From: Joanne Davis [REDACTED]
Sent: 30 January 2020 11:29
To: Simon Davis [REDACTED]
Cc: Karl Roberts [REDACTED] Neil Crowther [REDACTED]
Subject: ** Town Council Representation in relation to BR/282/19/PL - 2-4 Waterloo Square **
Importance: High

At the Town Council's Planning and Licensing Committee Meeting, held on 28 January 2020, Members considered planning application BR/282/19/PL. The Town Council wish to **OBJECT** to the application.

BOGNOR REGIS TOWN COUNCIL has considered planning application BR/282/19/PL and wishes to **OBJECT** on the following grounds:

Project Title:	Date:
Waterloo Square, Bognor Regis	01.10.19
Document Title:	Drawn by / Checked by:
Proposed Basement Level Floor Plan	SR / GG
Drawing Scale / Sheet Size:	Client:
1:200 @ A3	B5 ltd
Drawing Status:	Drawing Number / Revision:
PLANNING	18.103.201

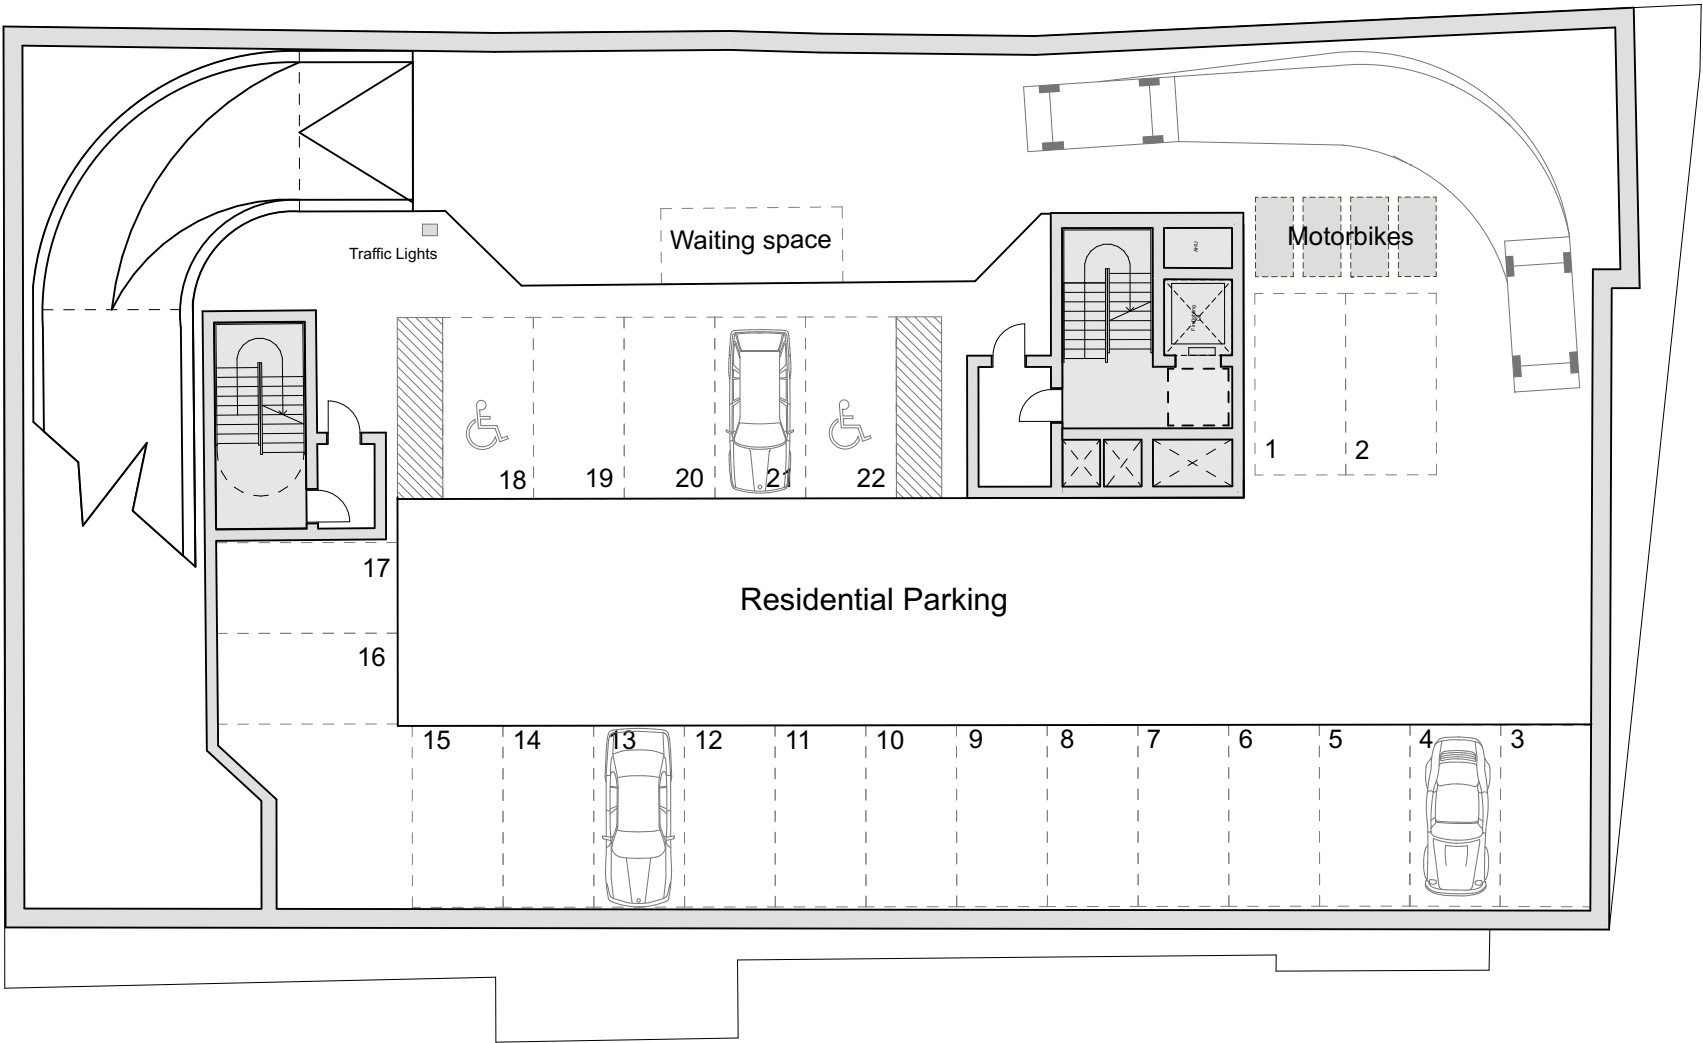
The proposal for 22 No. spaces on a basement level car park is significantly less than the calculations of the WSCC Car Parking Demand Calculator, which envisions a total demand for 45 spaces. The Local Highways Authority have themselves, in consultation, stated that access into the basement level car park is not wide enough, with a waiting space that not only results in a car overhanging the footway, but has been provided on the wrong side. The 2 No. disabled parking bays also fail to meet the requirement of having an additional width of 1.2m on each side.
